STATE OF NORTH CAROLINA
DEPARTMENT OF TRANSPORTATION

SUBJECT: **SUPPLEMENT to Nationwide Permit 23 and 33 Application** for the proposed replacement of Bridge No. 274 over Canoe Creek on SR 1248 in Burke County. Div. 13, FA Proj. # BRZ-1248(3), State Proj. # 82853501, WBS 33408.1.1, **TIP # B-4042, Action ID: SAW-2007-3497-312.**

REFERENCE: NW 23/33 Permit Application dated October 8, 2007.

Permit Drawing  
Sheet 4 of 6  
Revised

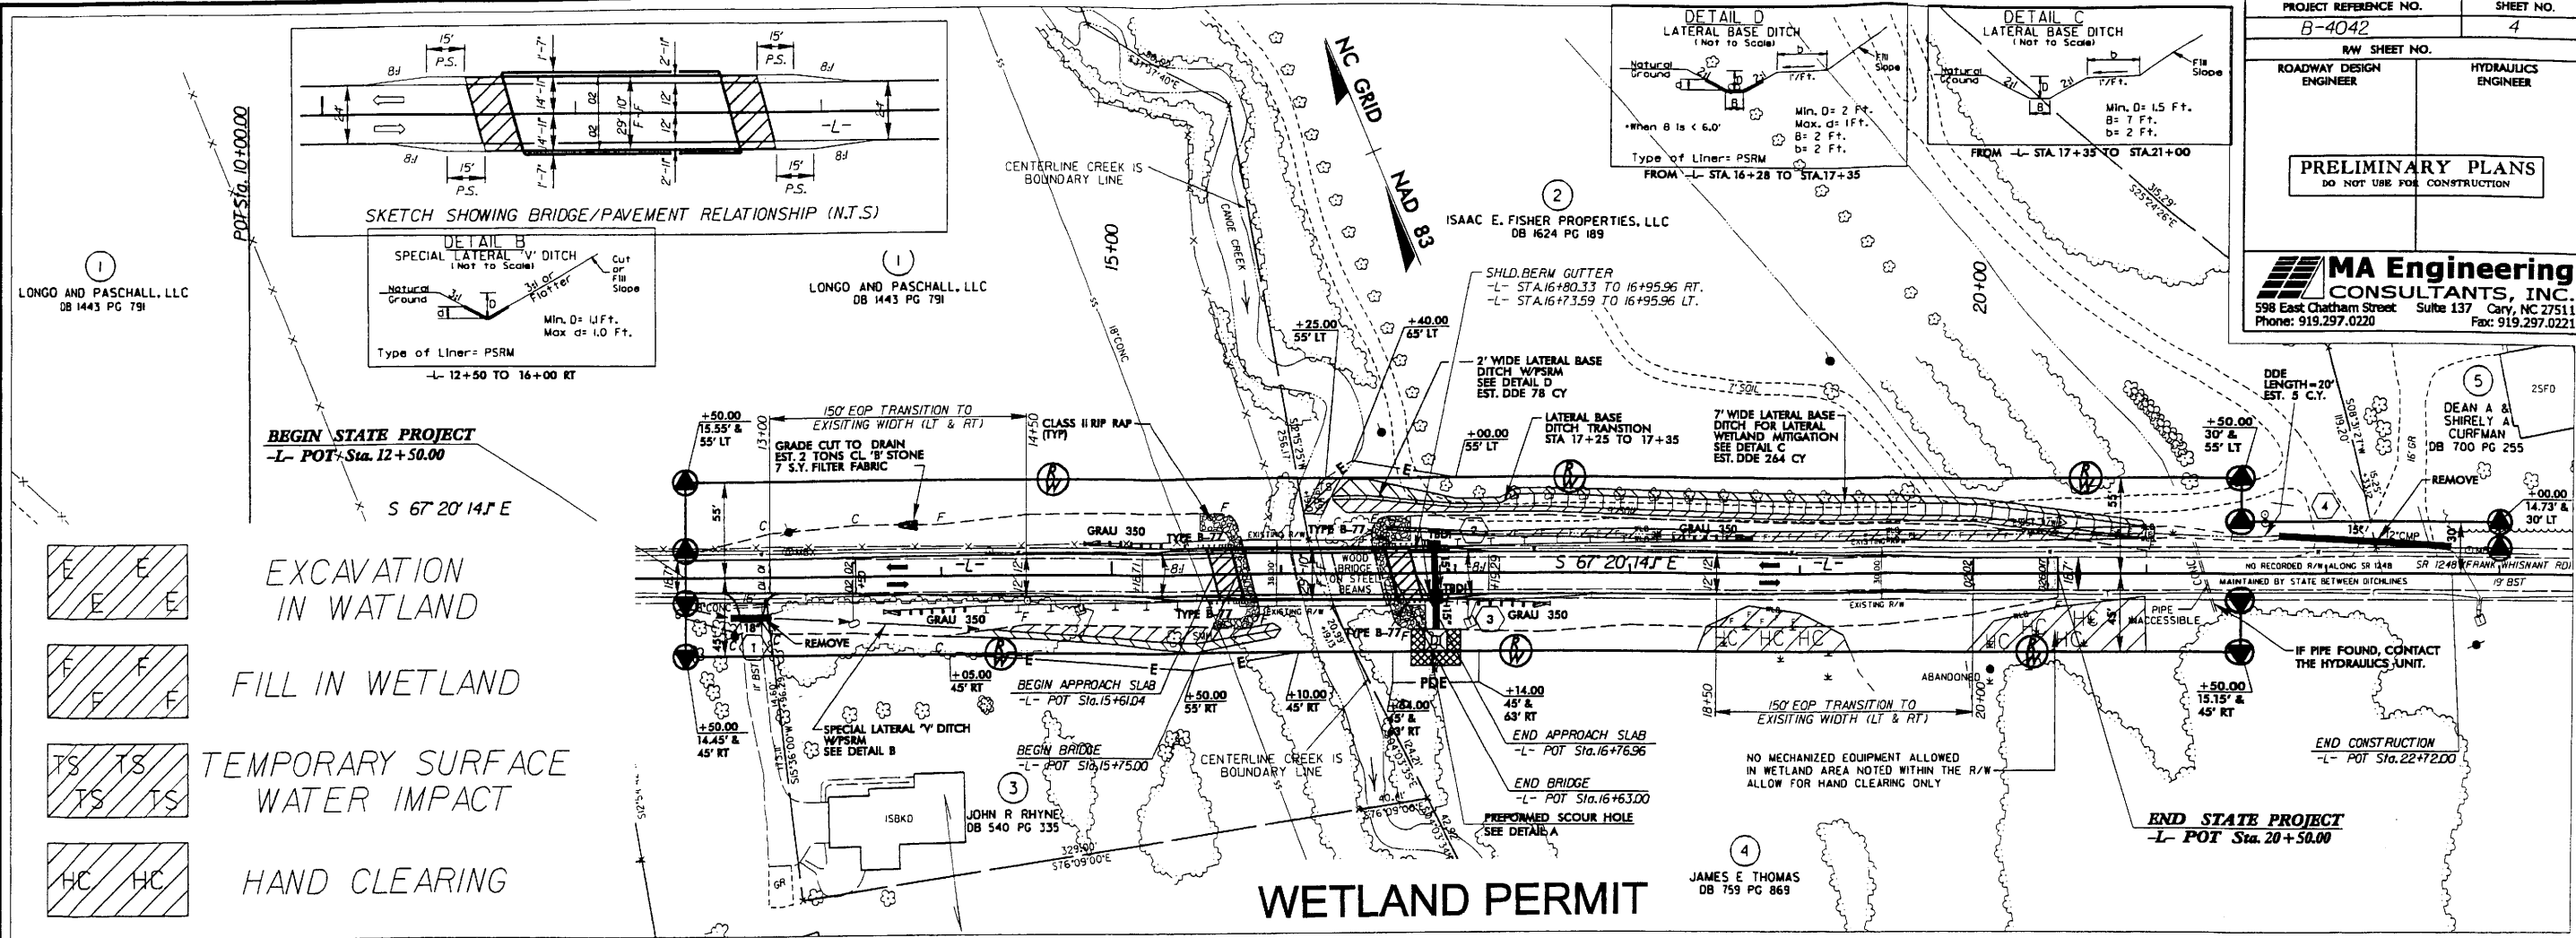
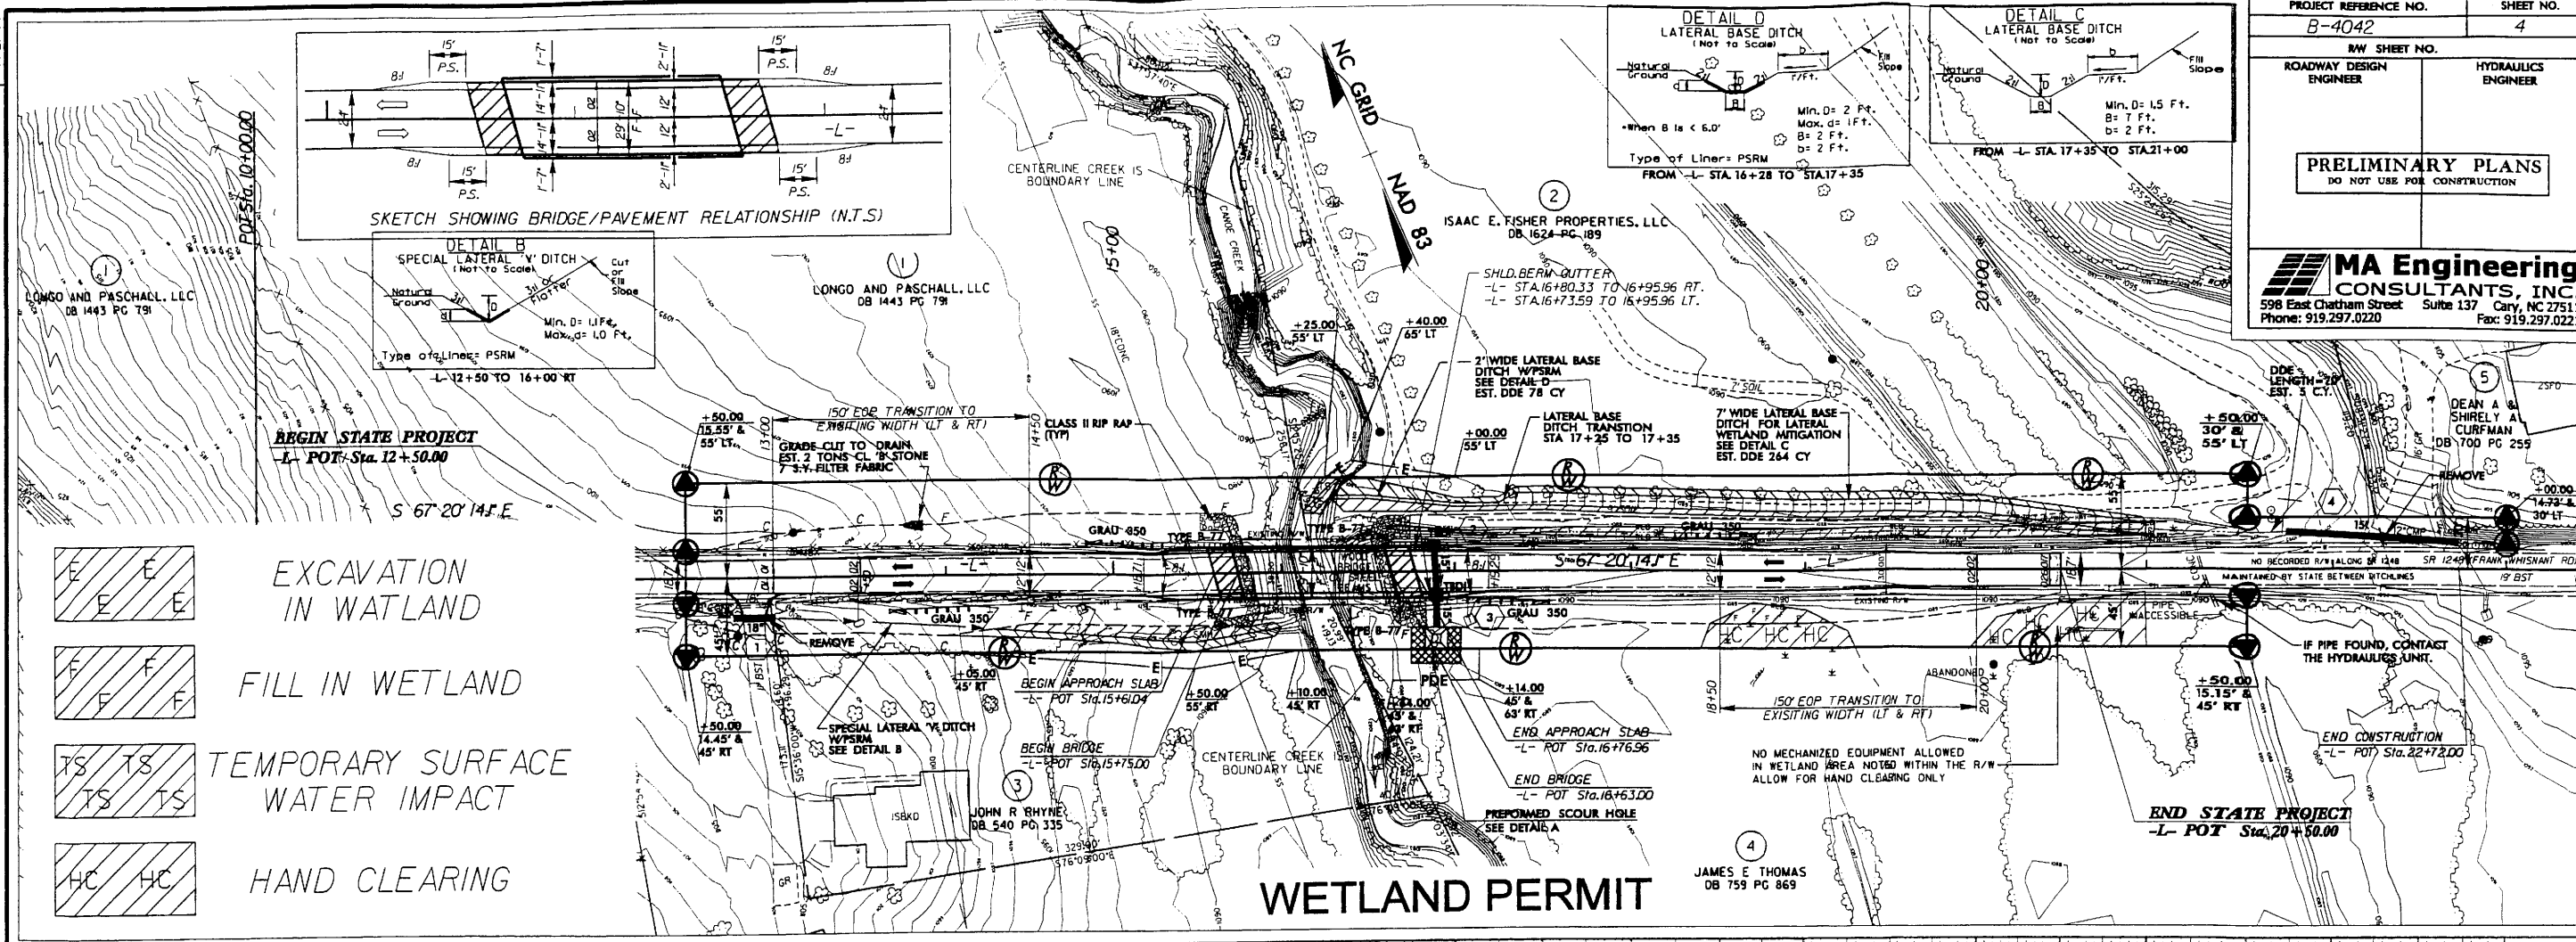
Please consider this Supplement to the Nationwide 23/33 Permit Application for the referenced project sent on October 22, 2007. Attached is a revised drawing (Sheet 4) showing impacts to a newly formed wetland located within construction limits for the proposed bridge replacement. At the time of the December 2006 field visit, this wetland did not exist. It is believed to be the result of the adjacent delineated wetland expanding. The new area was discovered by DOT personnel in October while setting survey stakes for upcoming construction events. The Natural Environment Unit within PDEA was contacted immediately and visited the site in early November to investigate. The wetland expansion will result in an additional 0.01 acres of impact.
